OVERALL LANDSCAPE PLAN

Markup Summary

LANDSCAPE PLAN AREA A

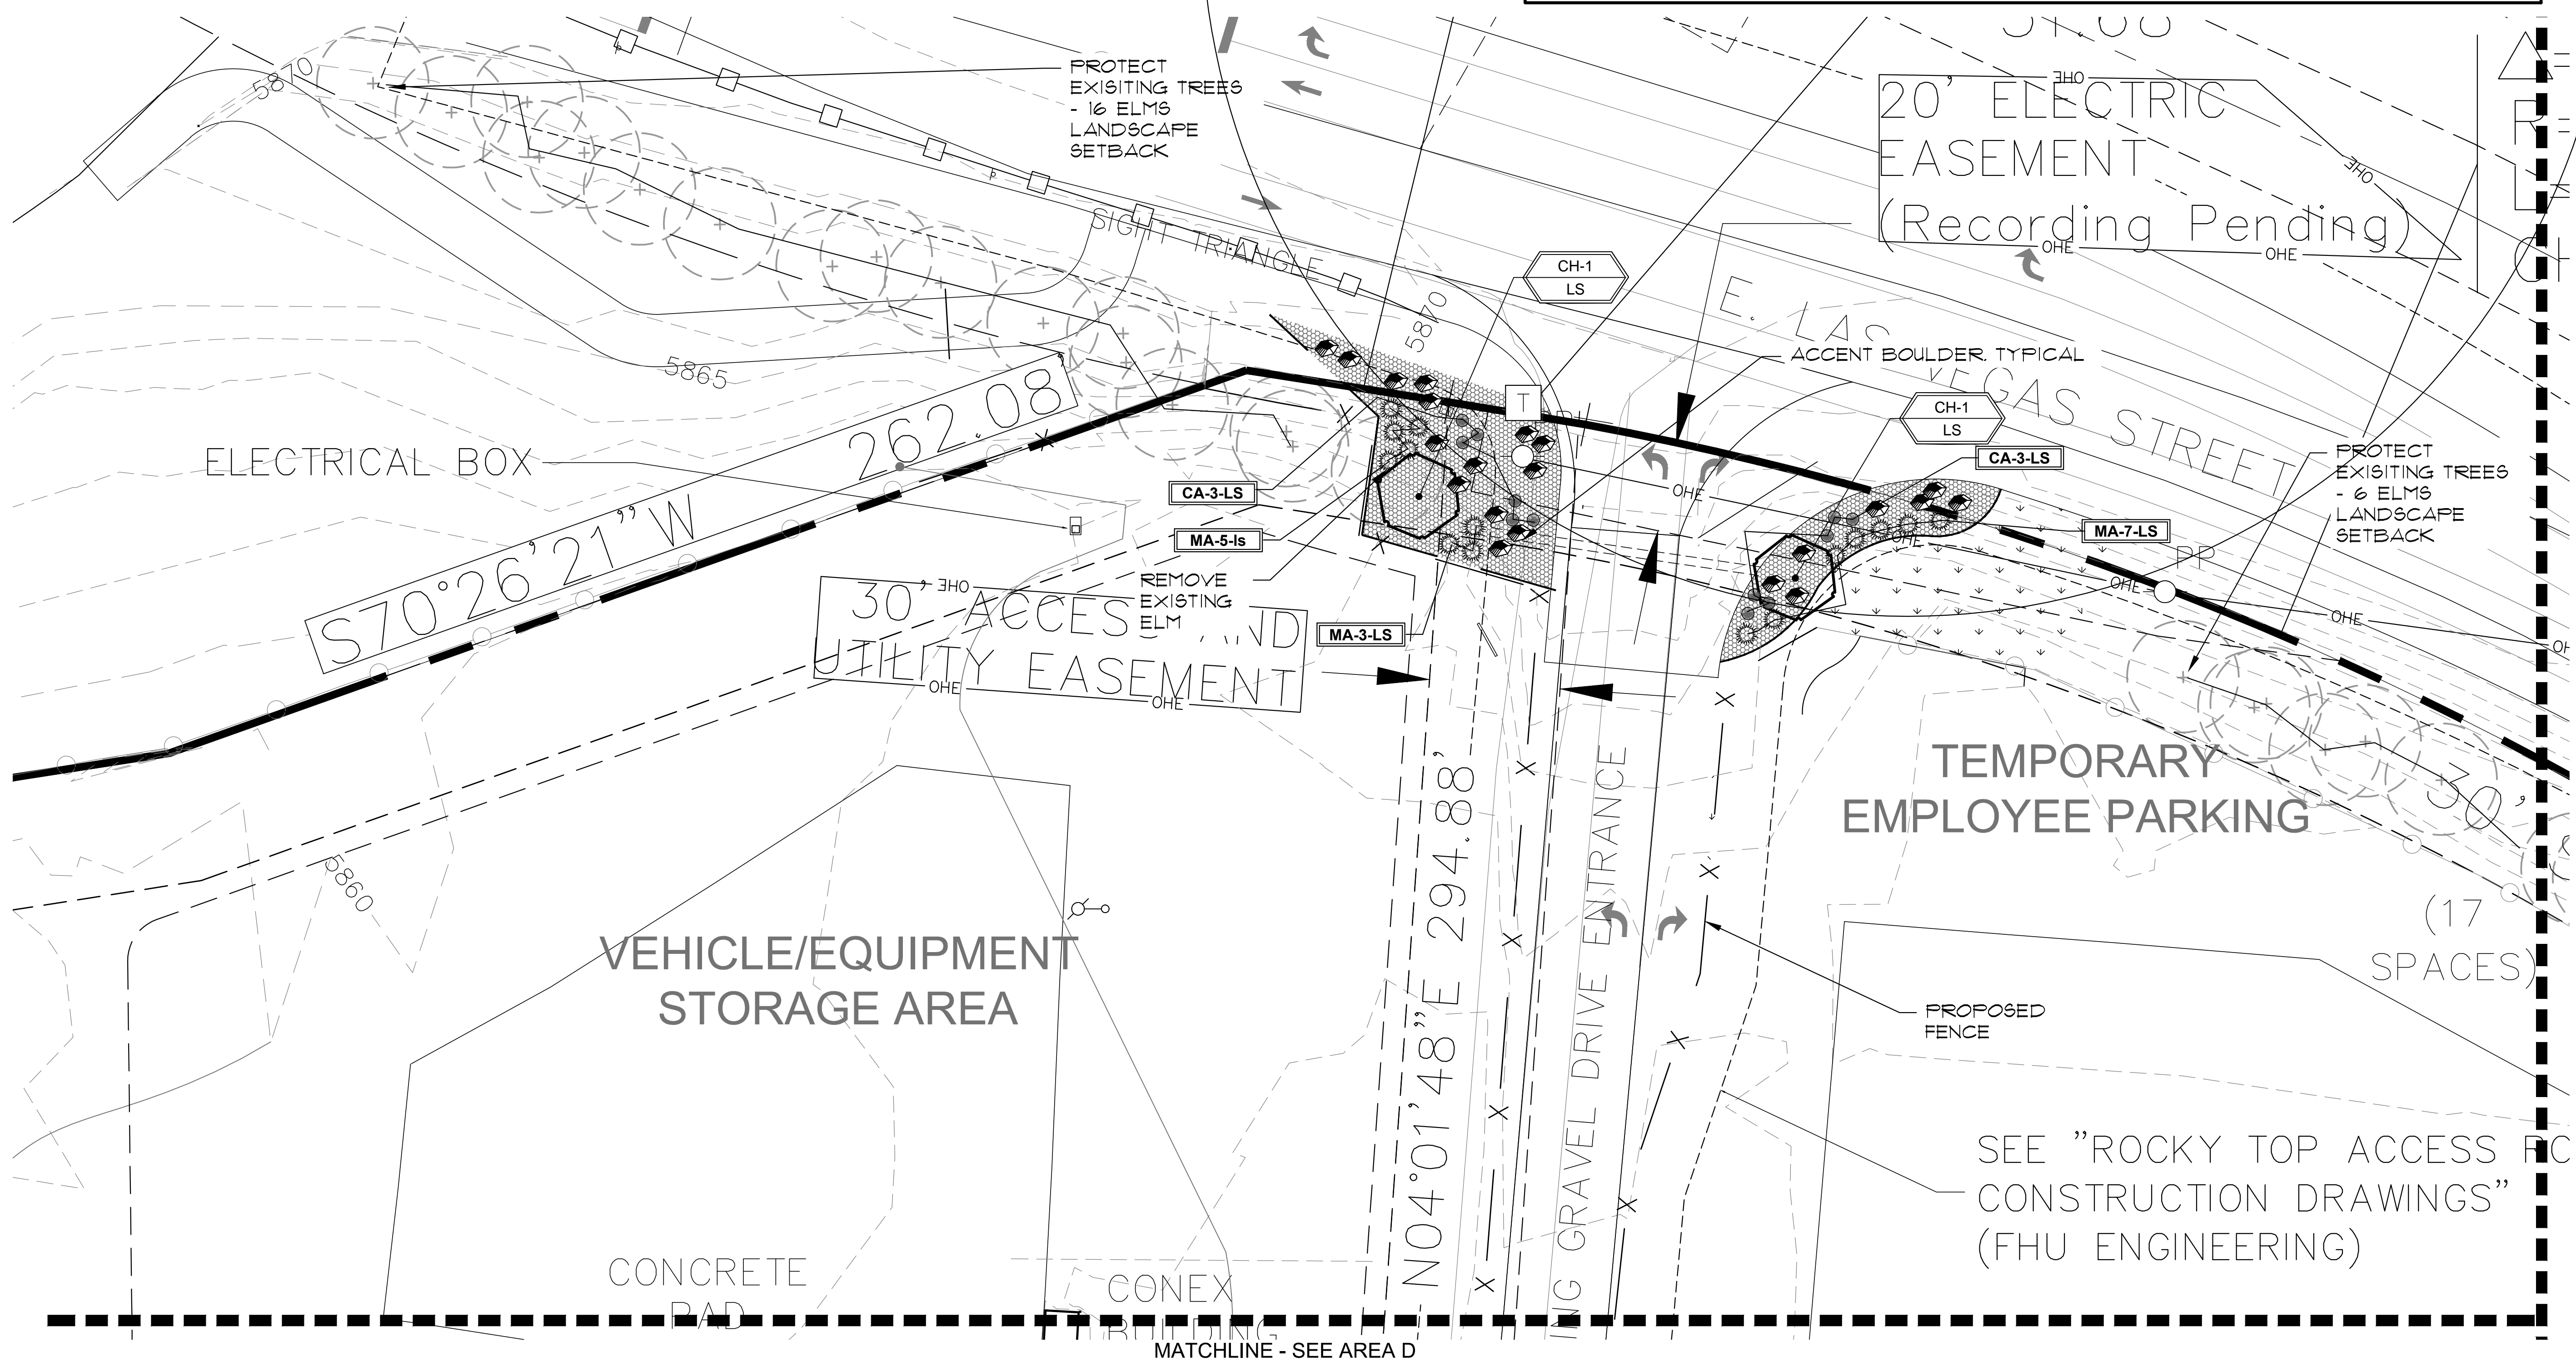
Please indicate that the existing trees are intended to stay.

<p>Please indicate that the existing trees are intended to stay.</p>	<p>Subject: Text Box Page Label: 1 Lock: Locked Author: dsdseigny Date: 4/24/2019 4:11:33 PM Color: ■</p>	<p>Please indicate that the existing trees are intended to stay.</p>
 <p>Landscaping requirements pertain to the whole site. What are the required tree along Las Vegas and how many are being provided? Please provide information in the plant schedule. If the existing trees along Las Vegas are to remain, the plan must reference that information.</p>	<p>Subject: Text Box Page Label: 2 Lock: Locked Author: dsdseigny Date: 4/24/2019 4:17:17 PM Color: ■</p>	<p>Landscaping requirements pertain to the whole site. What are the required tree along Las Vegas and how many are being provided? Please provide information in the plant schedule. If the existing trees along Las Vegas are to remain, the plan must reference that information.</p>

**LANDSCAPE PLAN
AREA B**

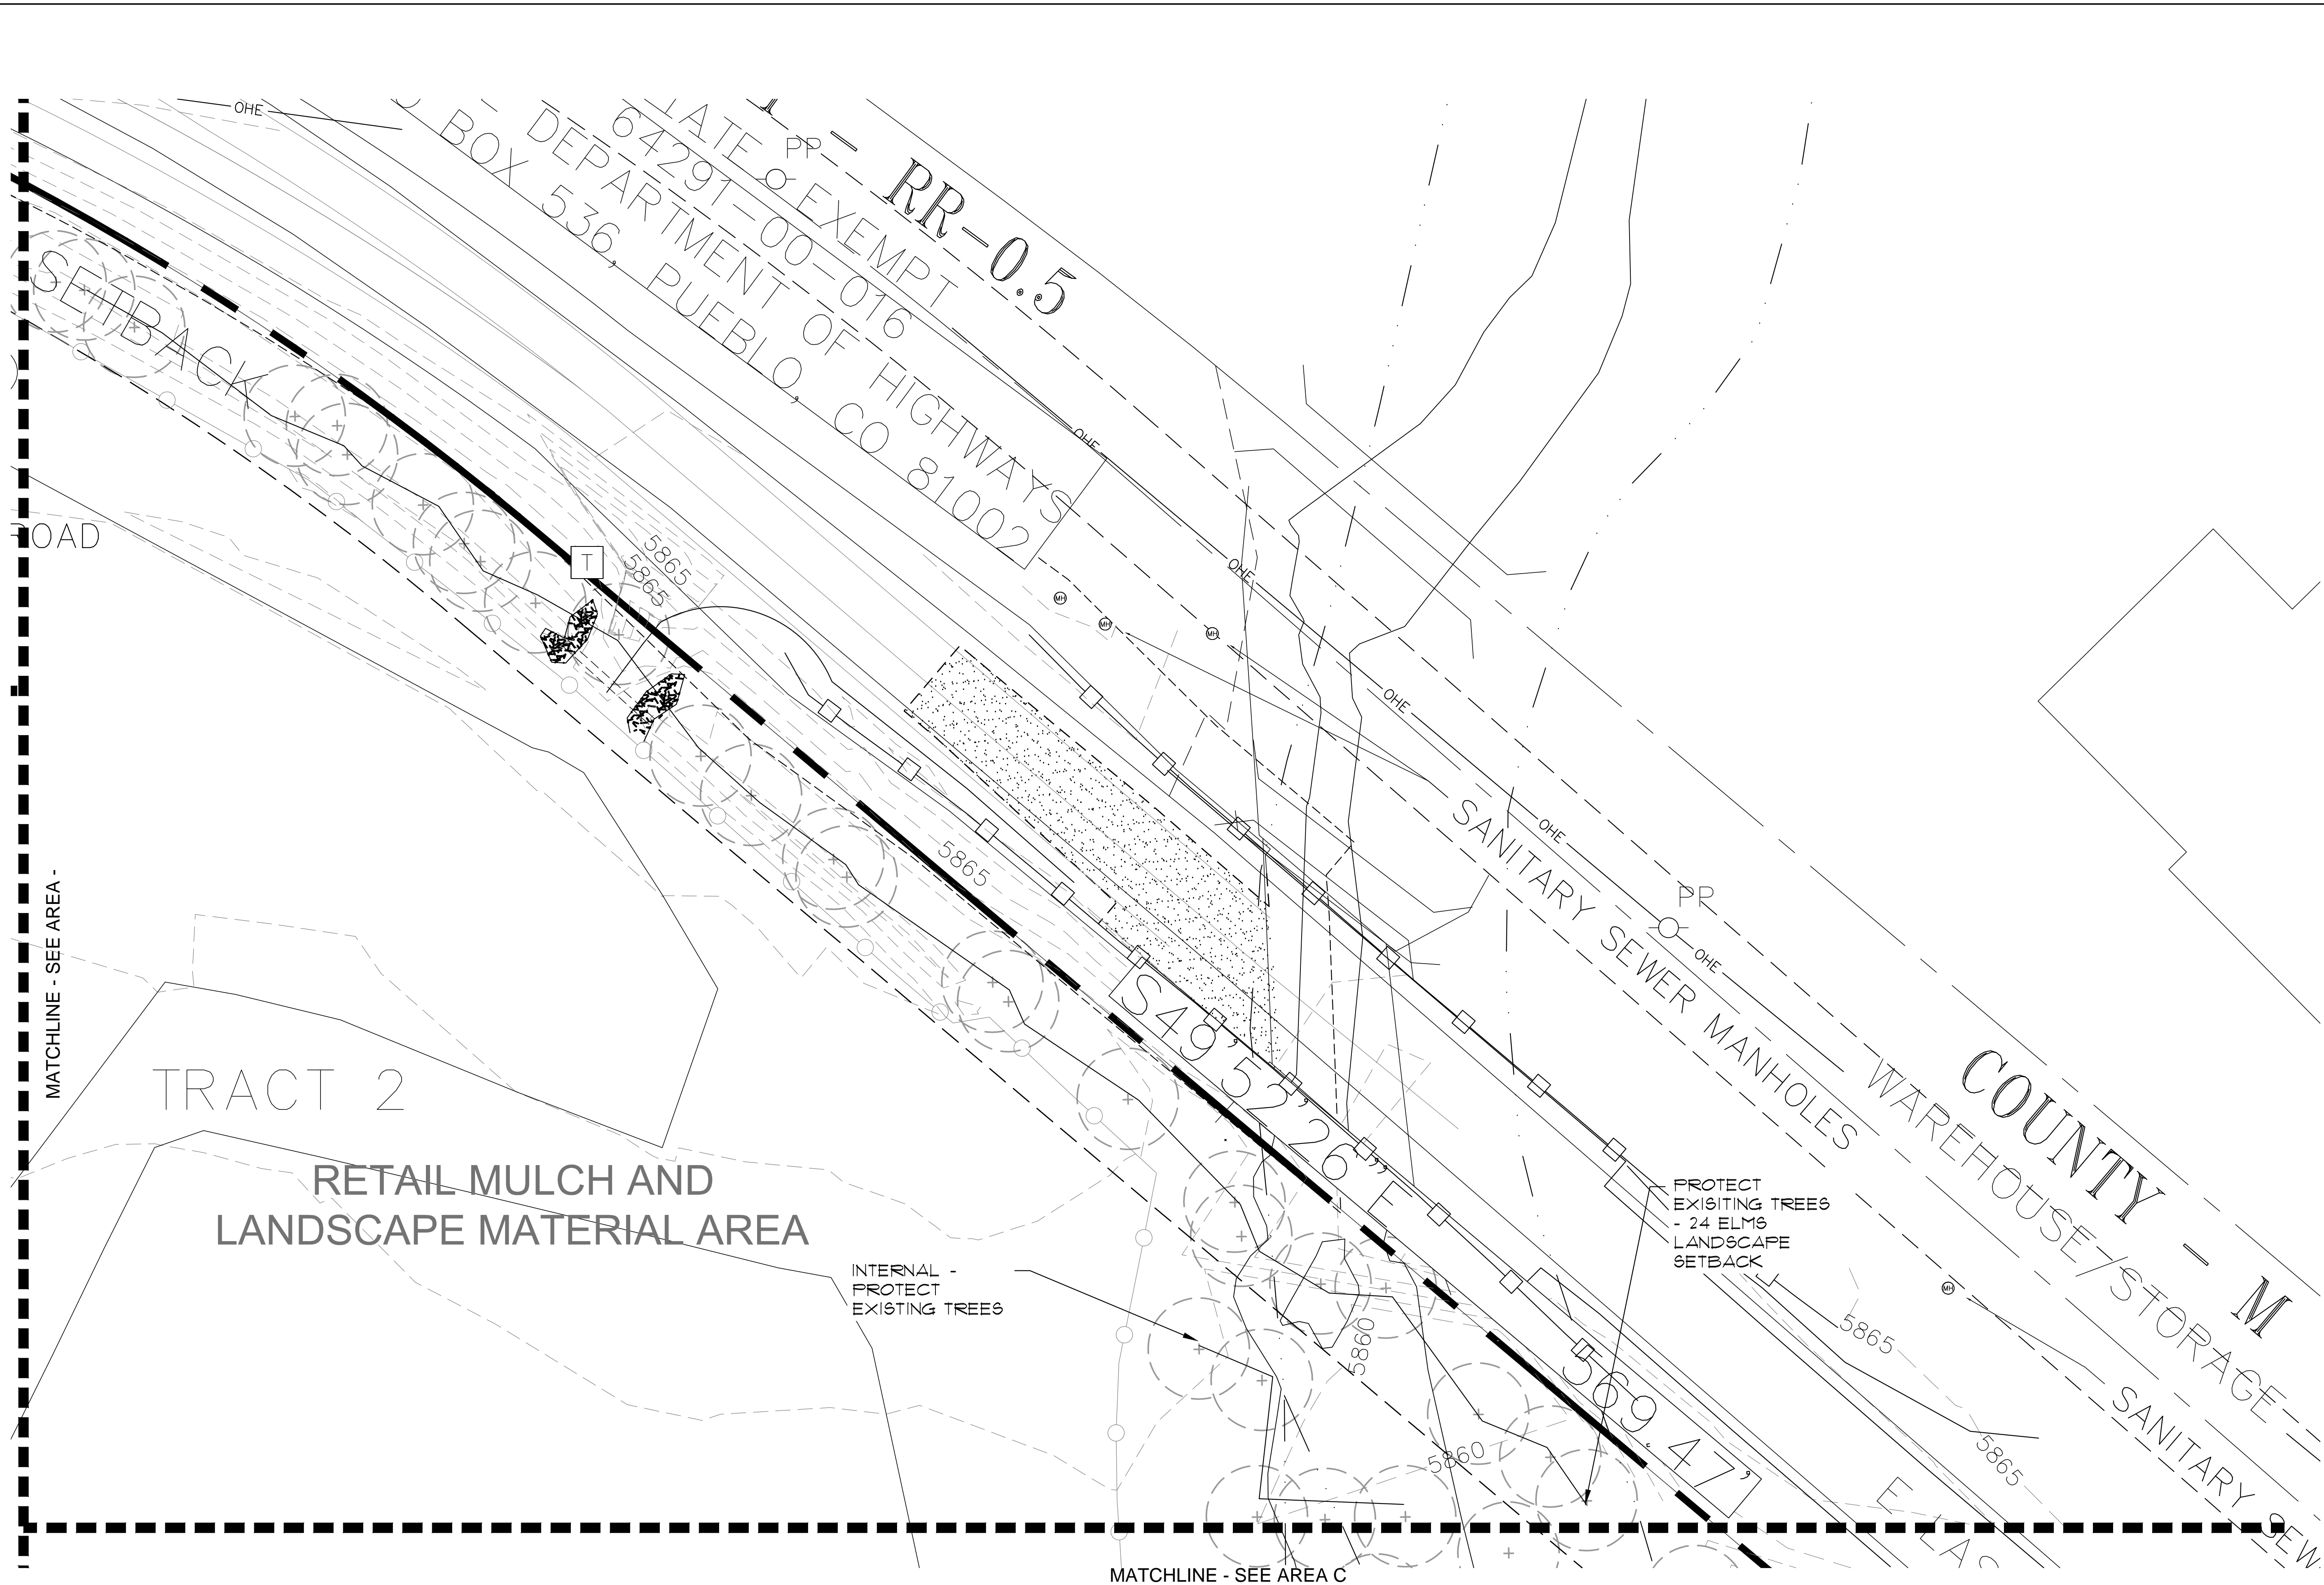
Section 6.2.2(C) Parking Lot Landscape Requirements. There are no trees indicated in this parking lot detail.

<p>Section 6.2.2(C) Parking Lot Landscape Requirements. There are no trees indicated in this parking lot detail.</p>	<p>Subject: Text Box Page Label: 3 Lock: Locked Author: dsdseigny Date: 4/24/2019 4:17:19 PM Color: ■</p>	<p>Section 6.2.2(C) Parking Lot Landscape Requirements. There are no trees indicated in this parking lot detail.</p>
